CITY OF ALBUQUERQUE

August 9, 2022

**Re: Avalon Subdivision – 98th & Bluewater
Erosion and Sediment Control Plan
Engineer's Stamp Date 4/12/2022 (K09E048)**

CITY OF ALBUQUERQUE PUBLIC WORKS DIVISION ENGINEERING GROUP			
98th / Bluewater Commercial Development EROSION & SEDIMENT CONTROL PLAN			
DESIGN REVIEW COMMITTEE	CITY ENGINEER APPROVAL	LAST DESIGN UPDATE	MO./DAY/YR.
CITY PROJECT NO.	ZONE MAP NO.	SHEET #	
676285	K-9-Z	18 of 24

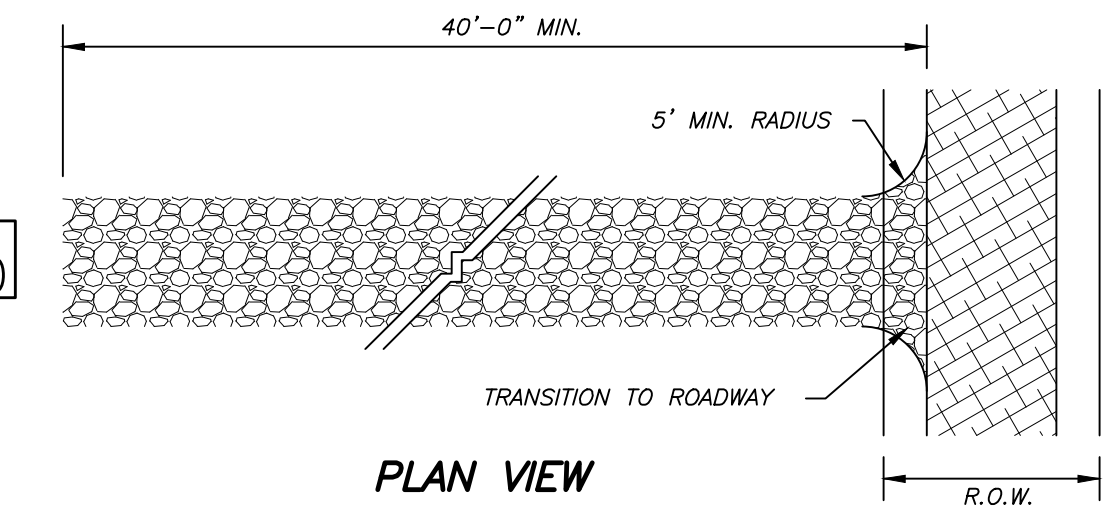
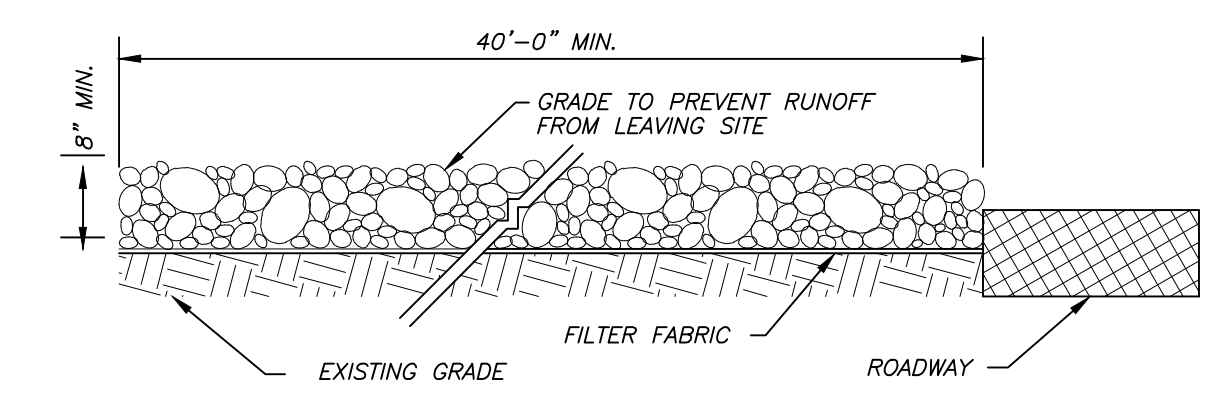
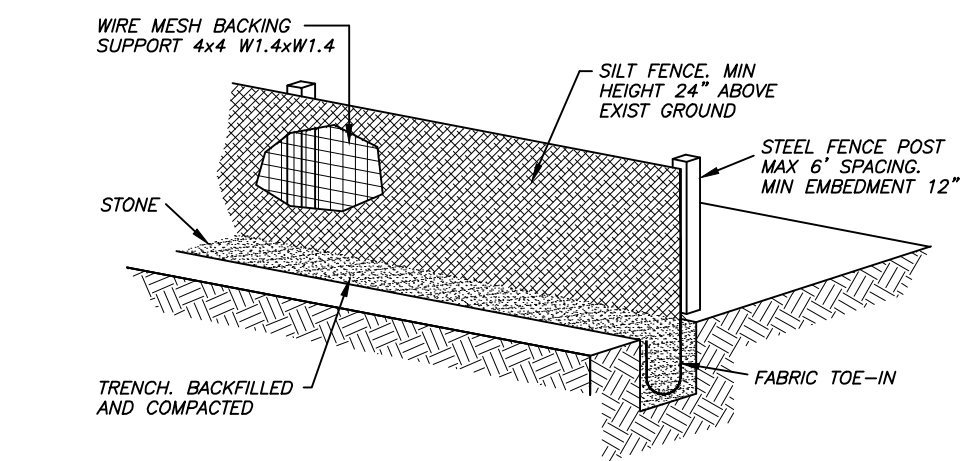
1. The ESC Plan can't be approved for Grading or Work Order until the property owner's NOI has been reviewed and approved by City Stormwater Quality.
2. The limits of disturbance must include all frontage improvements (CGP 7.2.4.b.i). Identify the limits of disturbance in the areas where the onsite vegetation is to be protected, the ungraded portions of the site, and provide fencing to protect those areas.

3. The SWPPP must include site-specific interim and permanent stabilization per CGP 9.6.1.c.i. Provide a specifications on the ESC Plan along with schedules for implementation per CGP 2.2.14. Label areas where existing vegetation is to be preserved and not graded at this time. Label areas to be stabilized with landscape rock (all areas in the public ROW) and show typical section and specifications. Label areas to be stabilized with vegetation and provide details and specifications.

4. Provide inlet protection upstream of the inlet on Volcano Rd. per CGP 2.2.10.
5. Design Sediment Traps and/or Sediment Basins in accordance with CGP 2.2.12 and provide calculations.

6. The ESC Plan must identify and document the rationale for selecting these BMPs and/or other controls. The ESC Plan must also describe design specifications, construction specifications, maintenance schedules (including a long-term maintenance plan), criteria for inspections, and expected performance and longevity of these BMPs per CGP 9.6.1.c.i.

7. Describe the nature and extent of construction activities (CGP 7.2.2.). Include the size of the property, and the size of the area of land disturbing activities onsite and offsite. Describe construction support activities and show staging area on the ESC Plan.

8. Soil information – add a table with name type, particle sizes, and Erodibility factor (CGP 2.1.1).
9. Add the City Standard ESC Notes (attached) on the ESC Plan.

10. Update the engineer's stamp date each time the plan is changed.
